**WELWYN HATFIELD BOROUGH COUNCIL  
ASSISTANT DIRECTOR (PLANNING)**

**DELEGATED APPLICATION**

**Application No:** 6/2024/2170/FULL  
**Location:** Telephone Exchange Wigmores North Welwyn Garden City AL8 6PH  
**Proposal:** Installation of an aluminium louvre following removal of 2x window panes on the first-floor east elevation  
**Officer:** Mr Raymond Lee  
**Recommendation:** Refused

TITLE
PROPOSED & EXISTING ELEVATIONS FOR
WELWYN GARDEN TELEPHONE EXCHANGE

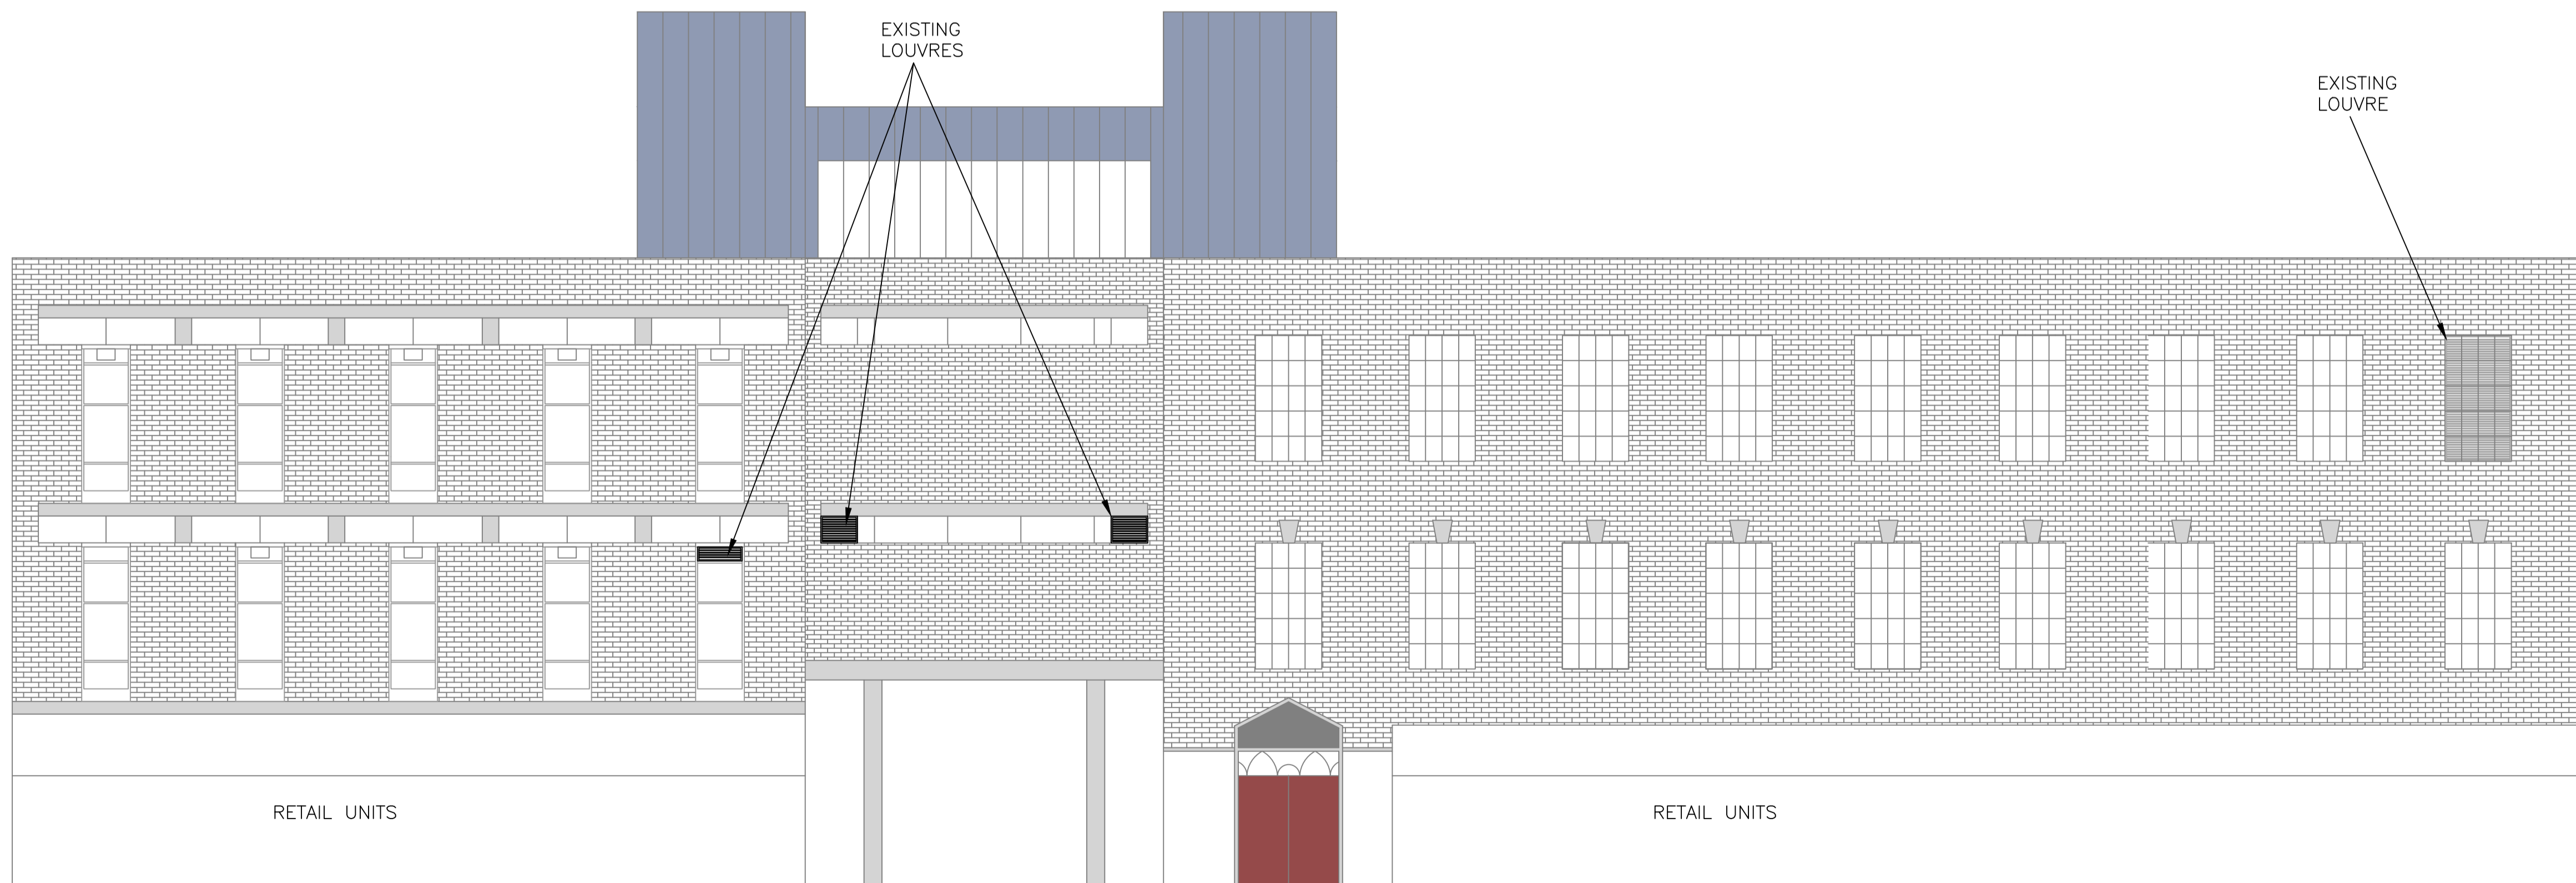
The property is located in the Welwyn Garden City Conservation Area. The proposal involves the replacement of two first floor window panes on the east facing front elevation of the building with metal louvres that each measure 1m in width by 2.35m in height. The submitted D&A statement suggests that the aluminium louvres would be of a mill aluminium finish to match existing louvres already installed in the building and they would be installed to the existing metal window frames.

The Council's conservation officer was consulted on the application and it was advised that the proposed installation of the louvres would disrupt the very regular and consistent fenestration pattern of the property and introduce an atypical feature to the first floor opening. The uniformity of the fenestration pattern and appearance is a key architectural feature of the Neo-Georgian buildings within the Conservation Area. Although the windows are located in a later extension of the building, this part still follows the uniform frontages seen within the original Welwyn Garden City buildings, preserving the character and appearance of the Conservation Area. However, the proposal would erode this key design principle.

Given that the development is located on the principal elevation of the building, it would be very visible within the public realm and appear as a discordant feature. It is acknowledged that there are existing louvers on the building, however these are small in size and are discretely located. Furthermore, one of the existing louvers to the upper floor window is set behind a frame that mimics the pattern of the window glazing bars which lessens its visual impact upon the streetscene. The proposed louvers would occupy a much larger opening, in a more visually prominent location. As such the proposed development would result in an uncharacteristic and unsympathetic design by reason of the inappropriate materials, design and scale.

<p>Accordingly, the proposal represents a poor standard of design and fails to preserve or enhance the character and appearance of the Welwyn Garden City Conservation Area, contrary to Policies SP9 and SADM15 of the Welwyn Hatfield Borough Council Local Plan, the Council's Supplementary Design Guidance 2005, Section 72 of the Planning (Listed Building and Conservation Areas) Act 1990, and the National Planning Policy Framework.</p>
<b>Impact on neighbours</b>	<p>The NPPF is clear that planning should be a means of finding ways to enhance and improve the places in which people live their lives. This means that authorities should always seek to secure high quality design and a good standard of amenity for all existing and future occupants of land and buildings. Policies SP9, SADM11 and SADM18 of the Local Plan seek to ensure that no new development would adversely affect the existing area either in terms of any built form or in terms of the operation of any uses from noise and vibration pollution.</p> <p>In this case, it is considered that the development would not result in any adjoining occupiers experiencing a detrimental loss of light, appear overbearing or unduly dominant. Furthermore, the proposed alteration to the openings would not afford any overlooking of the adjoining properties over and above the existing units or cause any significant harm in terms of noise and vibration.</p> <p>Consequently, the proposal would not have an adverse impact on the residential amenity of the occupiers of neighbouring buildings and as such will be in compliance with the National Planning Policy Framework, and Policies SADM11 and SADM18 of the Local Plan.</p>
